From: Ben Daines <[REDACTED]>
Sent: Wednesday, February 19, 2020 11:39 AM
To: Maria Tomalova <Maria.Tomalova@arun.gov.uk>
Cc: Luke Torres <[REDACTED]>; Martyn White <Martyn.White@arun.gov.uk>; Chris Barker
[REDACTED]
Subject: RE: Y/105/19/PL & Y/106/19/L

Y/105/19/PL & Y/106/19/L

The proposal is for the conversion of, and alterations to, existing barns to create 3 dwellings, along with the erection of car barns, a store, a replacement pump house, demolition of a C20 barn and associated landscaping and parking.

Drawing Title	Proposed Plans - Barn 3
Scale	1:100 @ A3

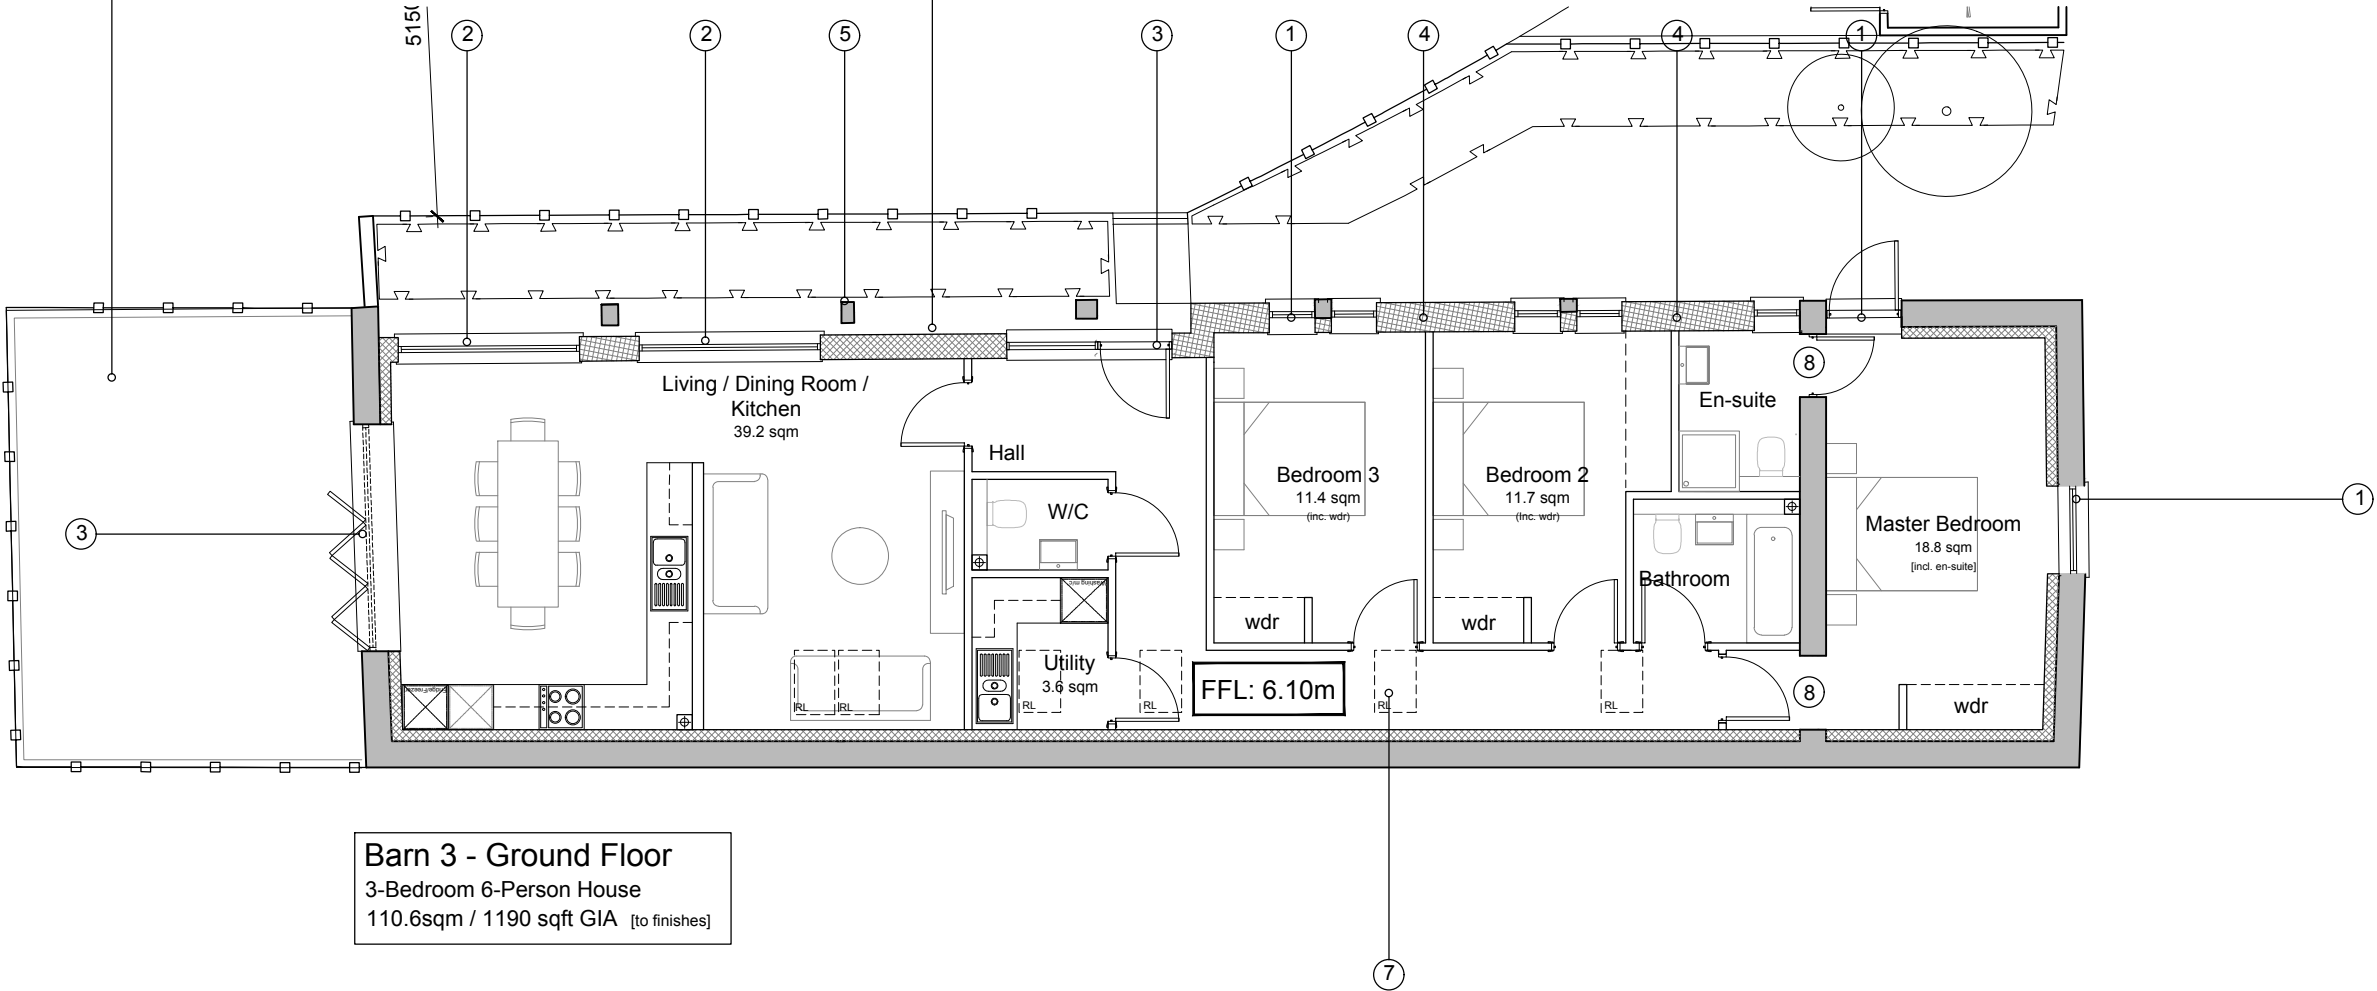
Likewise, it is noted that the building referred to as 'barn 3' is to include bi-folding doors. Such a feature is not normally associated with a barn and cannot be supported here. It is suggested that an alternative approach be considered which would result in the loss of less historic fabric, and a more appropriate design.

Yes, this can be altered to a pair of patio doors which will reduce the size of the opening in the existing barn. Again, where new external openings are proposed we will look to repurpose the flint elsewhere in the scheme.
